Re: Cuatro Development
1319 4th Street NW
Request Permanent C.O. - Accepted
Engineer's Stamp Date 11/17/14 (J14D173)

RE: Cuatro Development – 1319 4th St. NW (File: J14D173)
Grading & Drainage Plan, Engineer's Stamp Date 11-17-2014
Engineer's Certification Date 6-23-16

RE: **Cuatro Development**
Grading & Drainage Plan
Engineer's Stamp Date 10-27-2014 (File: J14D173)

GRADING PLAN
SCALE: 1" = 10'

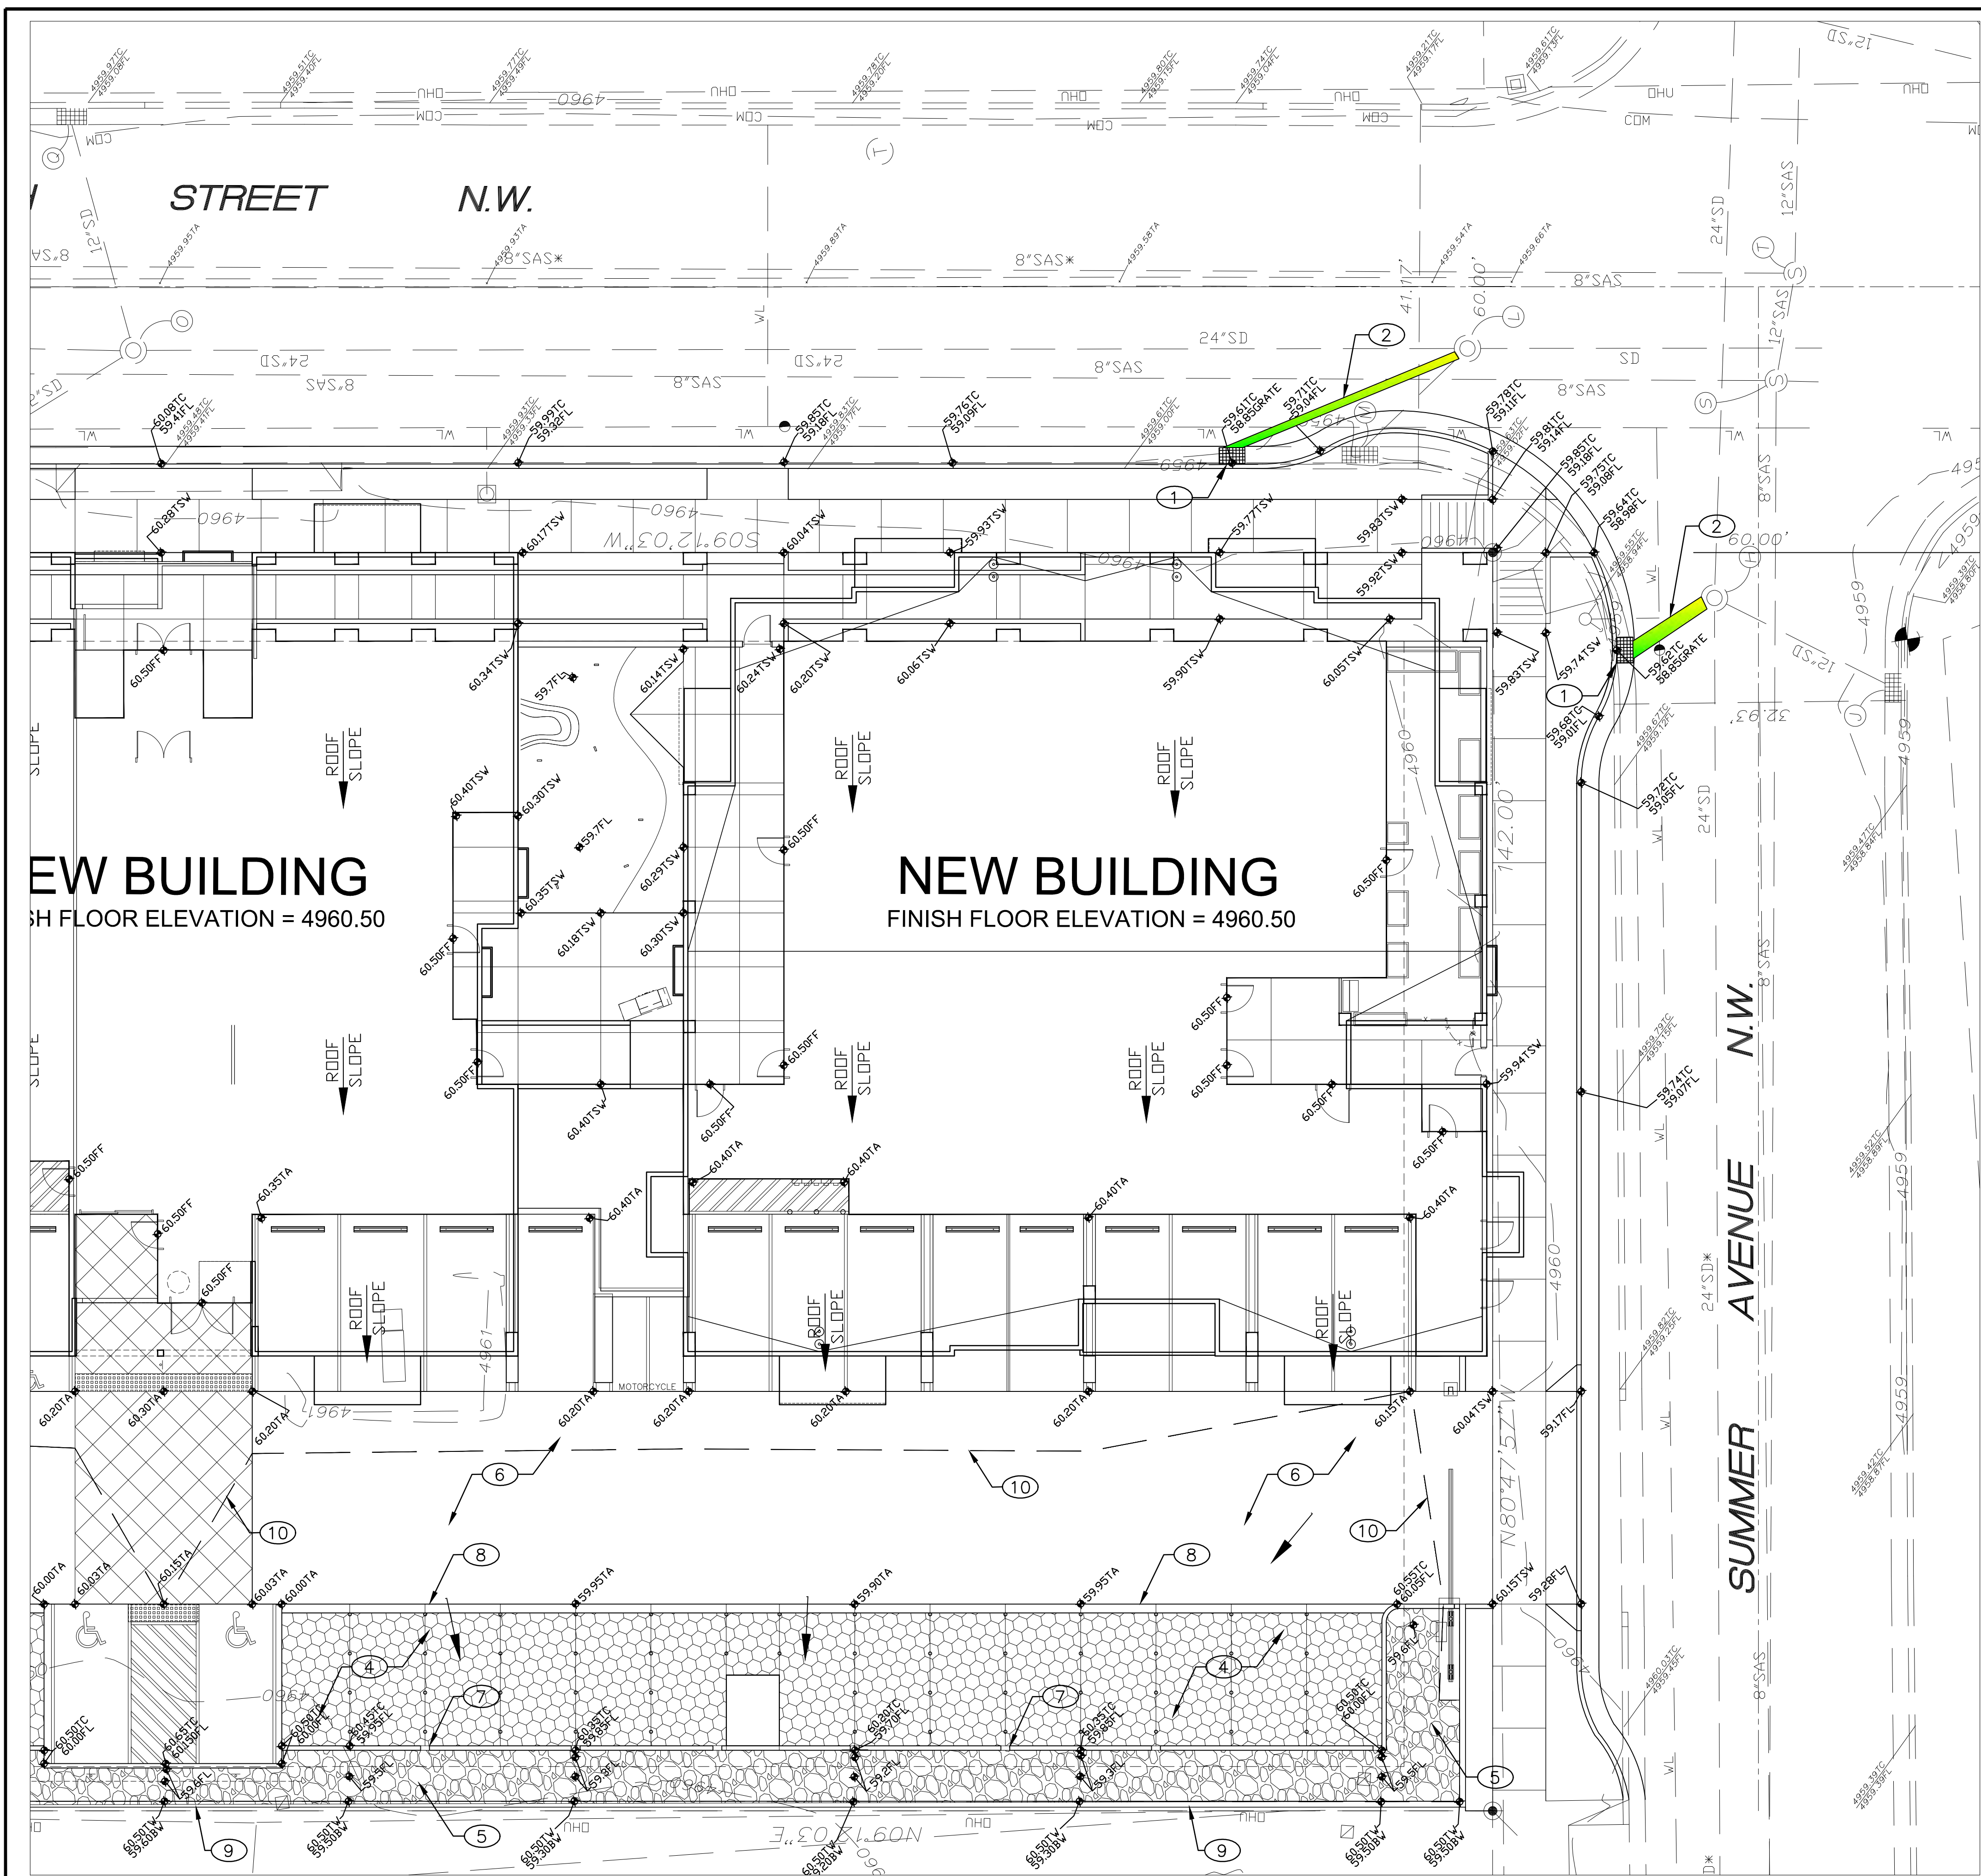
- Area with Geogrid system is to drain into channel along western boundary. The curb cuts are not deep enough, and the channel is filled with cobble. Per the Grading and drainage plan, the cobble should be approximately 8" – 12" below the top of curb. To rectify the problem, the following fixes are recommended:

- Core drill holes in the curb, just above the Geogrid—*no longer needed*
- Between the landscaping bushes in the channel, lower the top of rip-rap /cobble to about 14"-18" below the top of curb. The increase in depth is to compensate for the volume taken up by the landscaping bushes. Water should be able to flow from low spot to low spot between the bushes.

- In parking area, the infill material of the Geogrid system is extremely unstable and must be stabilized. Per the specs, a well – graded material was recommended (see snapshot below). Mixing in crusher fines, angular rock, and smaller diameter rock to improve gradation is recommended. ✓ *fixed*

was originally 8"-12"

✓
fixed
